19 September 2019

Our Ref: 180421

RE: Development Referral – Sydney Metro Service Facility – SSD 8784

DRAWING TITLE	CONCEPT PROPOSAL ELEVATIONS
SCALE:	1:1000 @A3
DRAWING NUMBER	12
PROJECT NORTH	PROJECT NORTH
REVISION	3

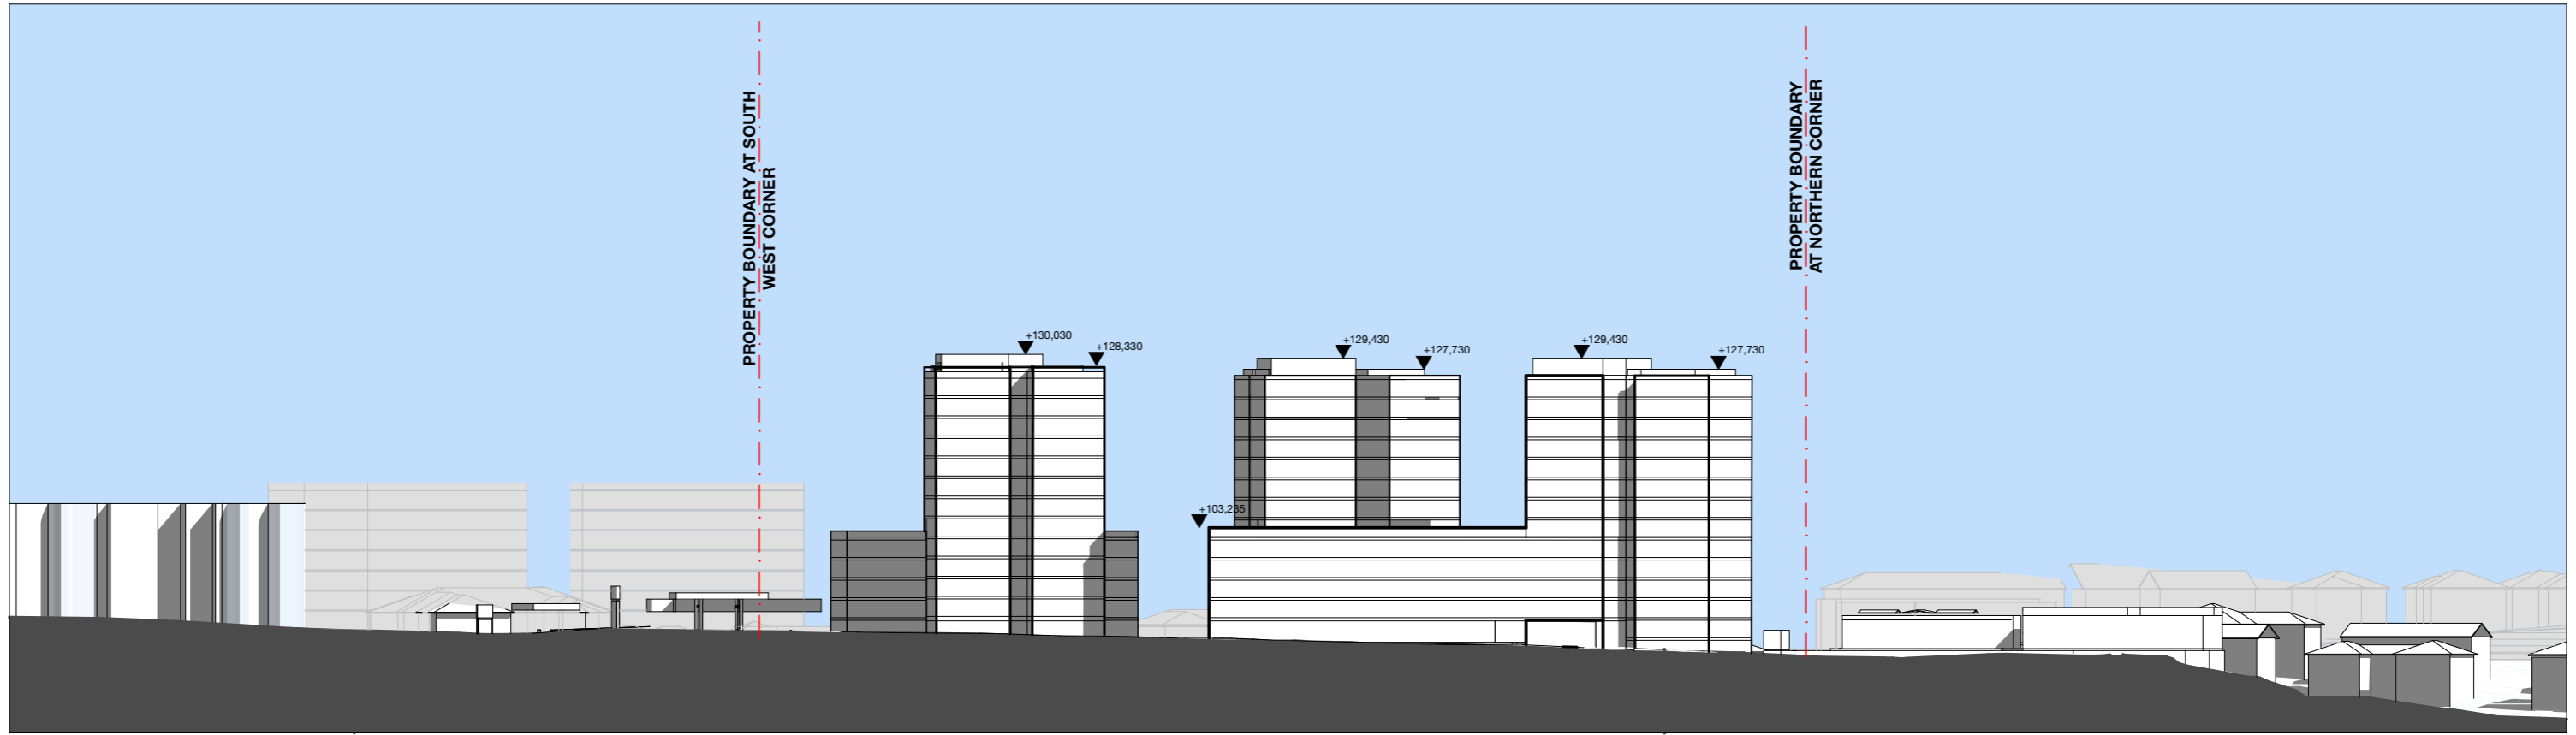
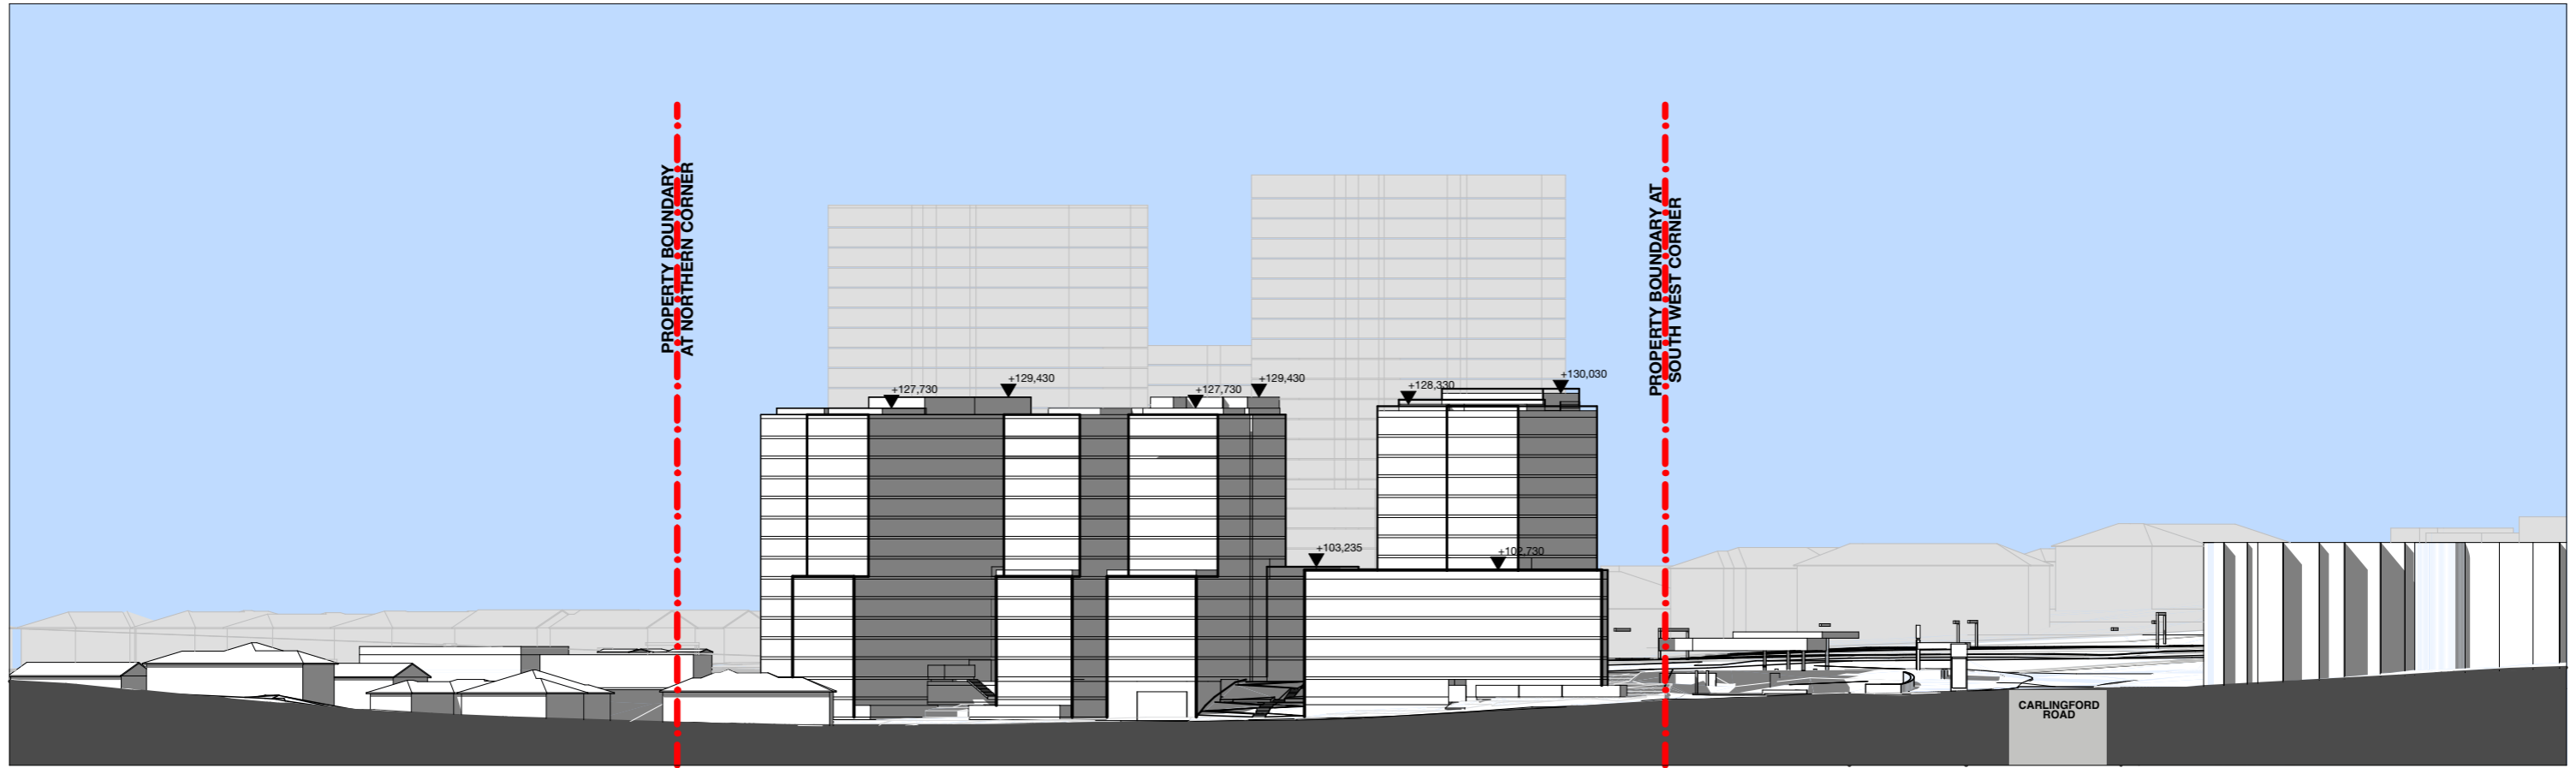
- Our records indicate that there is a major Sydney Water stormwater channel located along the vicinity of the north-western boundary, as well as a located within the north-western corner of the property.

- No building or permanent structure is to be proposed over the stormwater channel or within **1m** from the outside wall of the stormwater channel or within Sydney Water easement whichever is larger. Permanent structures include (but are not limited to) basement car park, hanging balcony, roof eaves, hanging stairs, stormwater pits, stormwater pipes, elevated driveway, basement access or similar structures. This clearance requirement would apply for unlimited depth and height.

- The applicant is required to submit the elevation drawings with the stormwater channel, to ensure that the proposed buildings and permanent structures are 1m away from the outside face of the stormwater channel and away from the Sydney Water easement.
